In reply please quote: 11/00020
Your Ref: SSD 15_7267

**SSD 15_7267 EXISTING RESOURCE RECOVERY FACILITY INCREASED
LICENCE CAPACITY – 20 DAVIS ROAD, WETHERILL PARK**

I refer to public exhibition of the above State Significant development. In response, Council requests that the following matters be taken into consideration by the Department under its further assessment of the proposal.

01 SITE PLAN

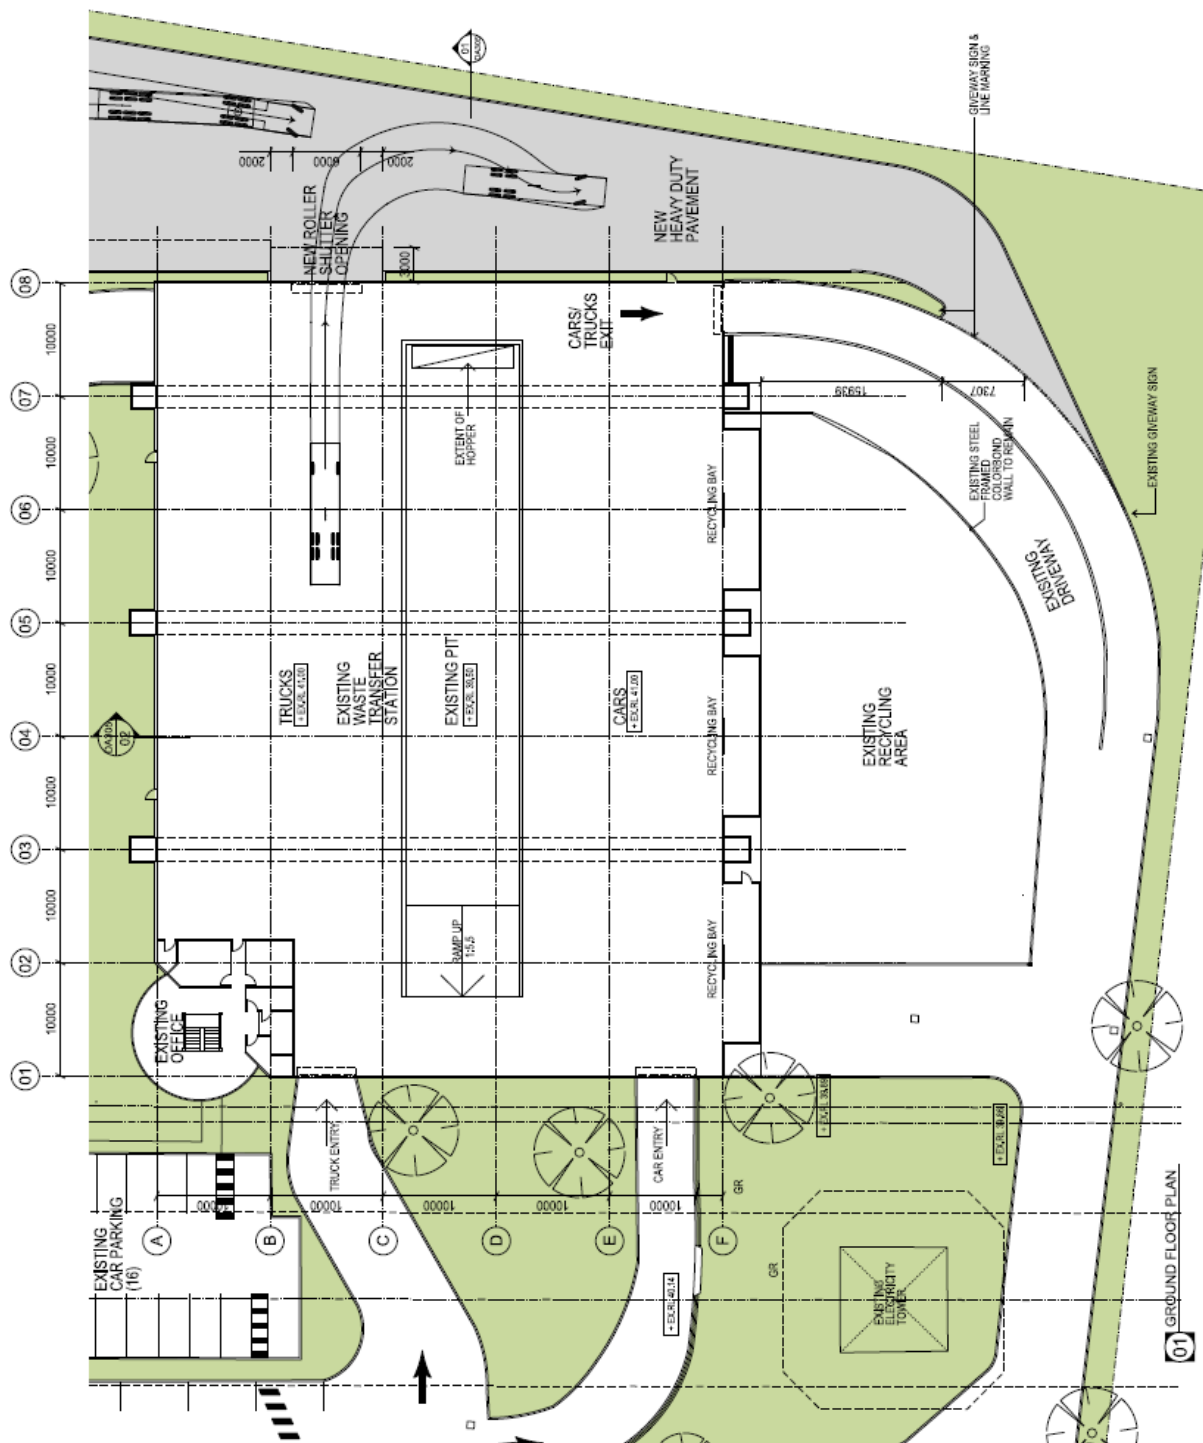
- The development proposal shall be referred to the Roads and Maritime Services for comments.
- The proposed disabled parking space shall comply with AS/NZS 2890.6:2009 (Off-Street parking for people with disabilities).

- To address the concerns associated with vehicles waiting to enter the weighbridge two (2) queuing lanes shall be provided.
